John Phillpott - RE: Sydney Opera House

As requested, we have reviewed the request to change the outfall to smaller twin pipes.

Subject: Sydney Opera House

SOH - EASTERN SEA WALL Proposed Amendments to Stormwater Outlets

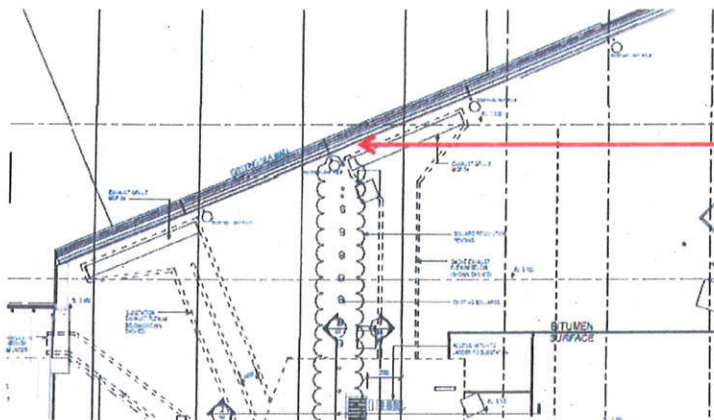
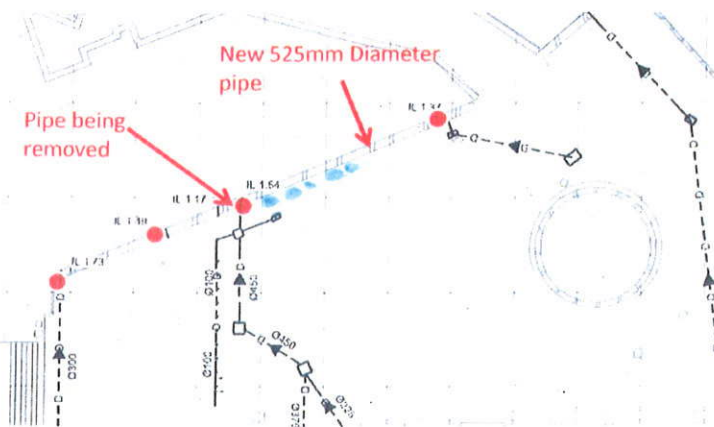
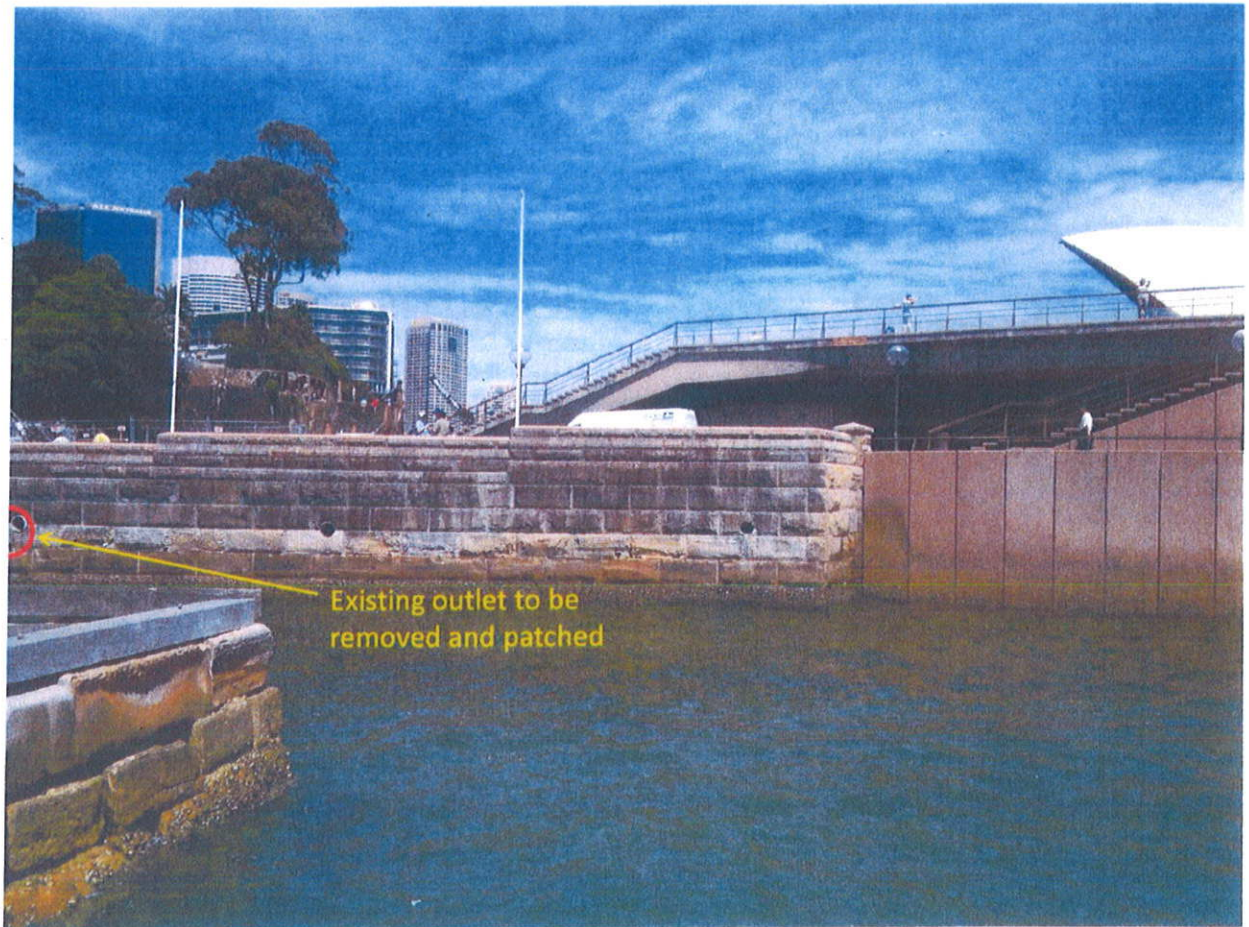
As discussed please find attached a copy of a letter I received from Sydney City Council this morning.

Can you please provide a response as requested, including confirmation of the size of the current outlet that is proposed to be plugged as part of these works.

The proposed design is for a 525mm diameter outfall which will drain the forecourt area. To change this pipe to twin pipes requires two 375mm diameter outfalls to provide the required discharge capacity. Whilst this is hydraulically feasible and was considered as an option, we believe there are more disadvantages to a twin pipe solution.

As the twin outfalls would originate from the same upstream pit we are limited by how much they can be separated. The pipes would be placed side by side with a 150mm gap between the pipes, thus the two outfalls would be within a 1m distance along the wall. Increasing the distance between the pipes would result in longer pipe lengths and even flatter pipe grades, the grades are already below the desirable standards. It would also require a larger upstream pit to accommodate the pipes which would increase the footprint of the excavation works.

It is our belief that installing two outfalls introduces additional flood risk to the site. The design outfall invert level is within the tidal range and will therefore be subject to sea water flowing back along the pipe. It is for this reason that non return valves (flap valves) will be installed on the ends of all pipes connecting into Pit A.4. These valves will prevent backwater flow effects through the stormwater network and are commonly used for this application. The valves would commonly be fitted to the seawall, however given the heritage importance of the sea wall in this location it was necessary to "hide" the valves in an additional pit. Whilst the aim of the valves is to reduce the effects of seawater levels on the performance of the drainage network, it is important to note valves are not failsafe. Should the non return valves become corroded or blocked in the open position by debris that (particularly in extreme tidal events) the sea water will back up through the stormwater drainage network. As each valve is a potential weakness in the network it is therefore good practice to limit the number of outfalls.

Every attempt was made to reuse the existing outfalls to minimise the impact on the seawall. However the invert levels of most of the existing outfalls was not compatible with the design.

The existing outfall which is being "plugged" is a 375mm diameter outfall and is located further north along

the wall than the new 525mm diameter outfall. It is not possible for this outfall to be reused as it is in conflict with the service plenum which will be constructed as part of the VAPS project. The reuse of this was thoroughly investigated as part of the design development, however the site constraints mean that it is not possible to connect to this existing outfall around the structure required for the services plenum. Please also note that the new 525mm diameter outfall will be constructed as part of the early works, whilst the plugging of the existing outfall will occur during the main VAPS works and will connect this stormwater line into the new outfall.
